Application number: 2019/91836	
What is the application for?:	Erection of 34 dwellings
Address of the site or building:	Land adjacent to Inkerman Court, Barnsley Road, Denby Dale, Huddersfield, HD8 8XA
Postcode:	HD9 3JH

Type of comment: An objection

ENGINEERING FEASIBILITY

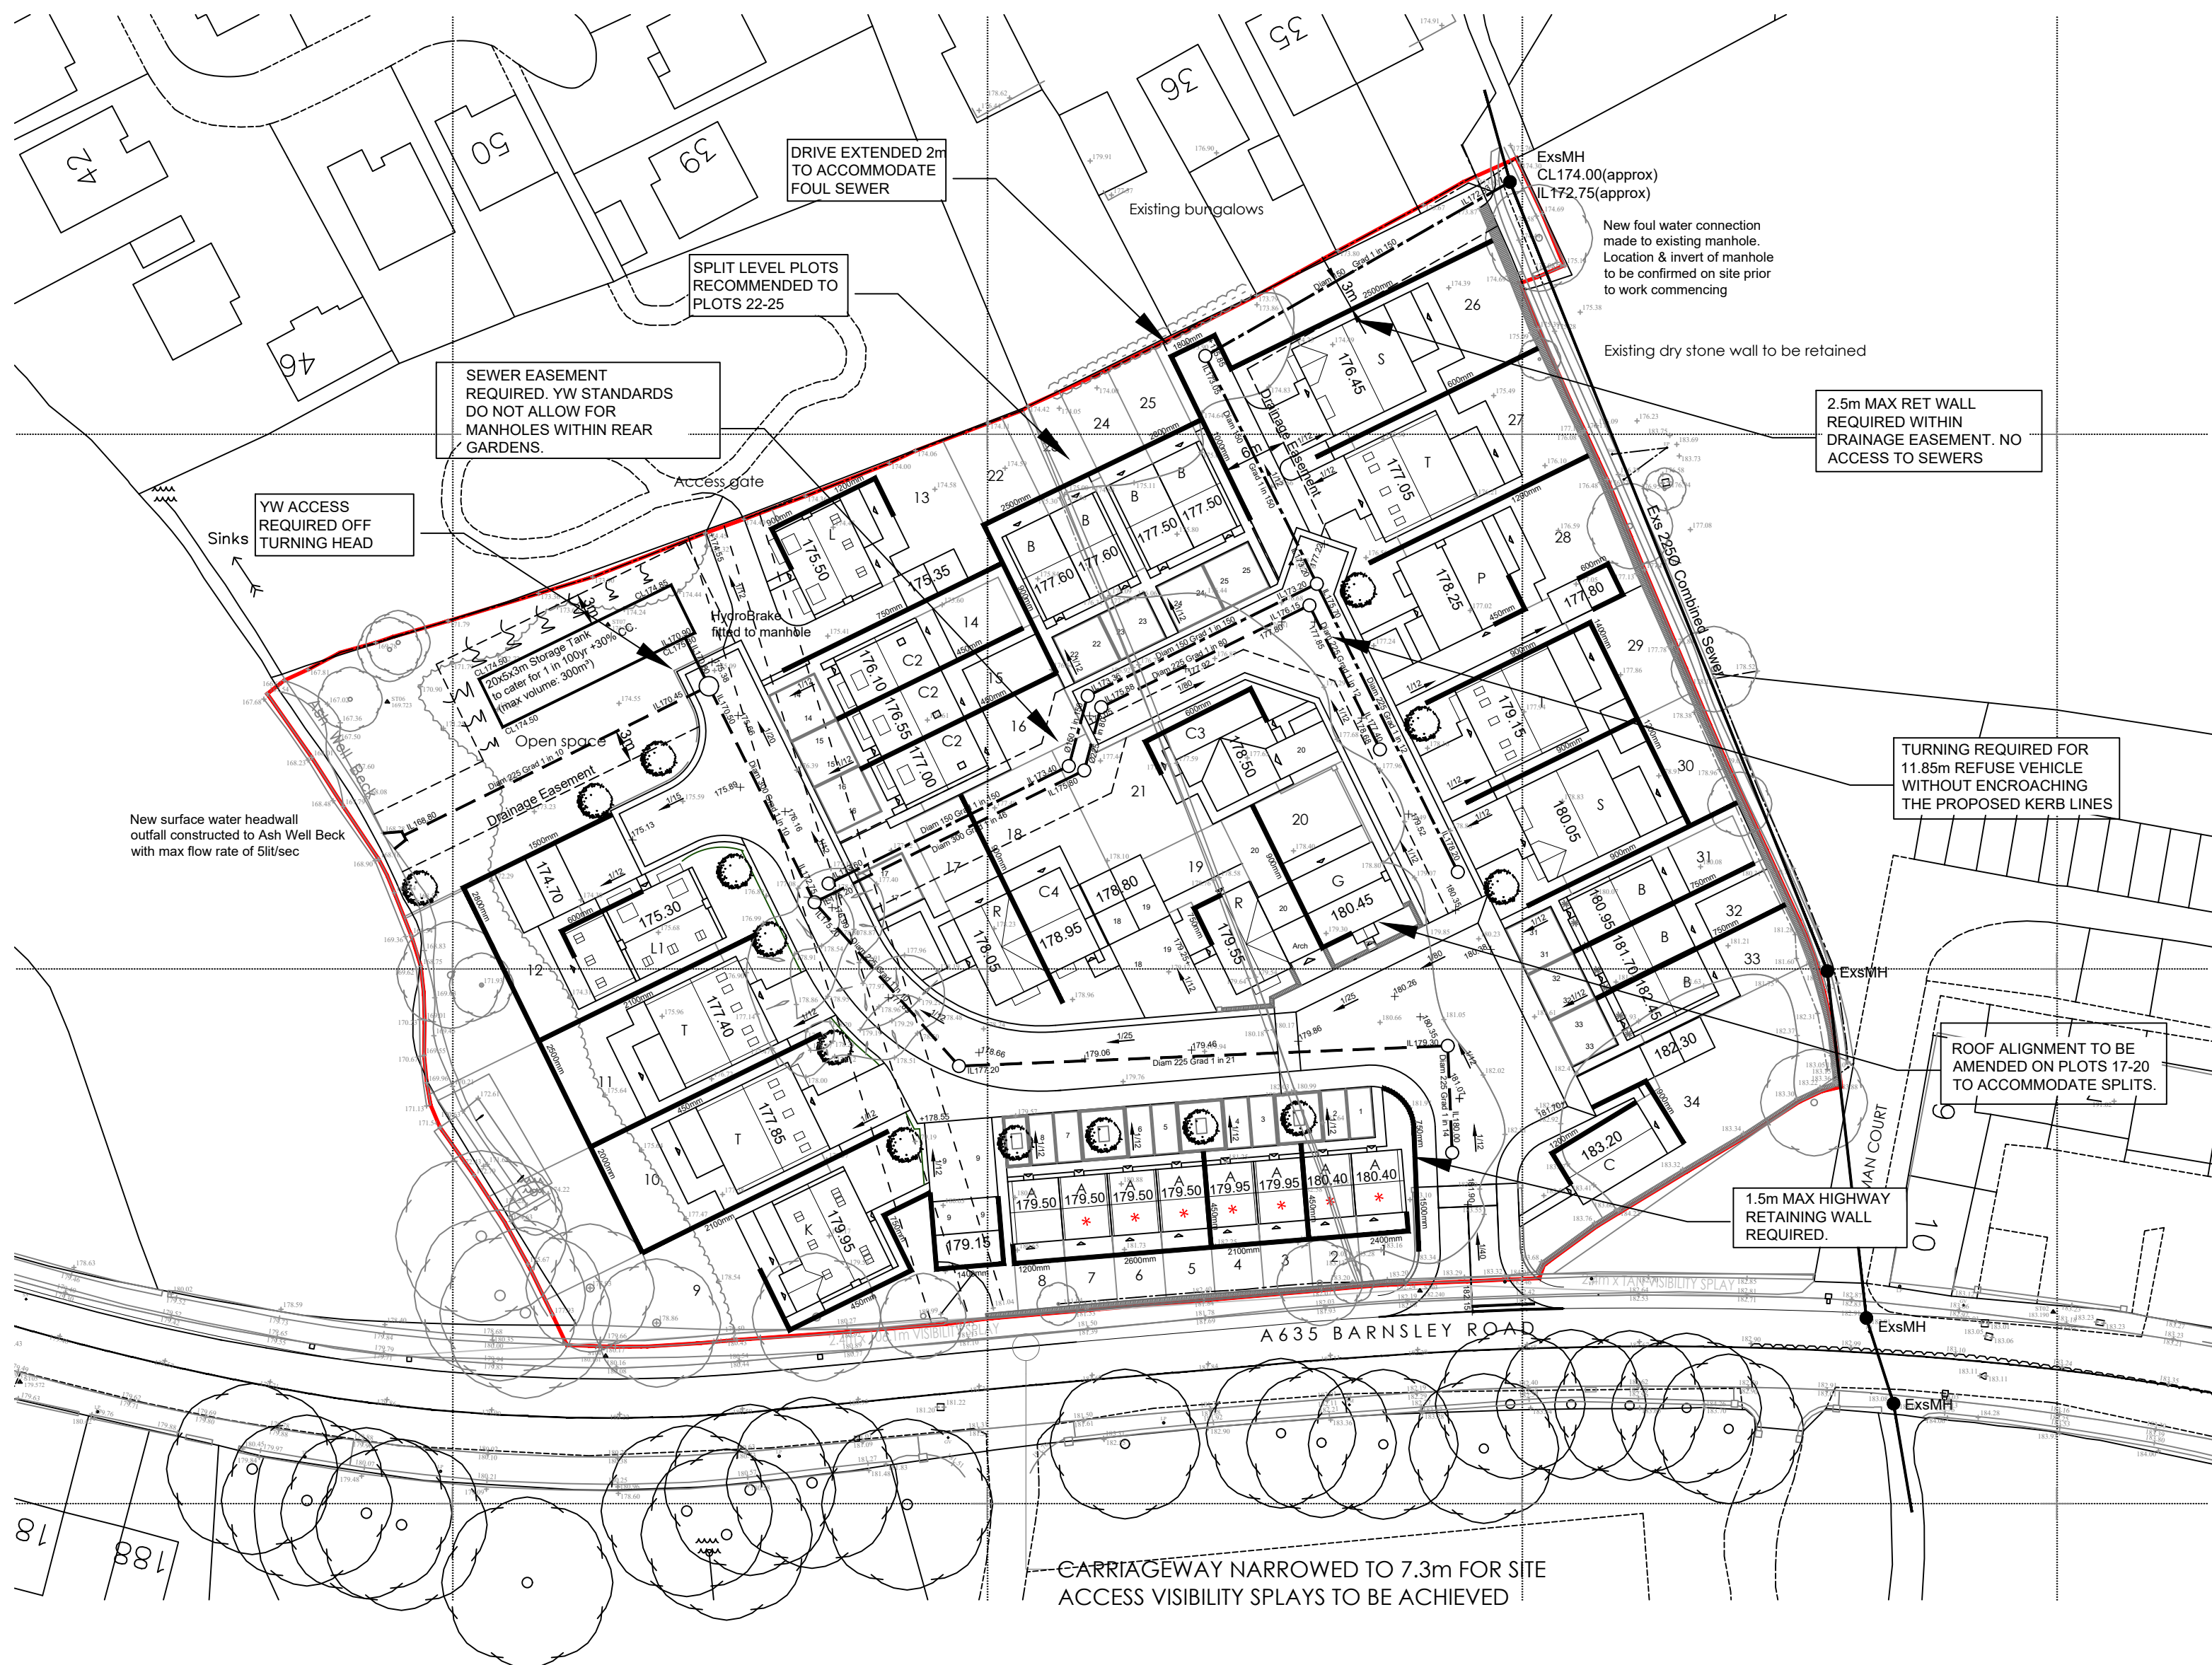
1. Drainage: The Flood Risk Assessment appears to understate the potential flood risk in 2 important aspects.

1.1. The land slopes towards the beck to the west of the site.

At present, our patio floods badly after very heavy rain as water runs off the hill, the water is not being absorbed sufficiently by the field above our garden, and that would not happen if the slope took the water towards the beck. If that field is substantially covered in concrete the water run-off into our garden will be seriously exacerbated with a likely scenario that the house itself will be flooded.

1.2 Any possible problem would be a hundred year event.

Climate change means the "hundred years" is no longer the case. Over the past 10 years the flooding referred to in 1.1 has occurred 5 or 6 times!
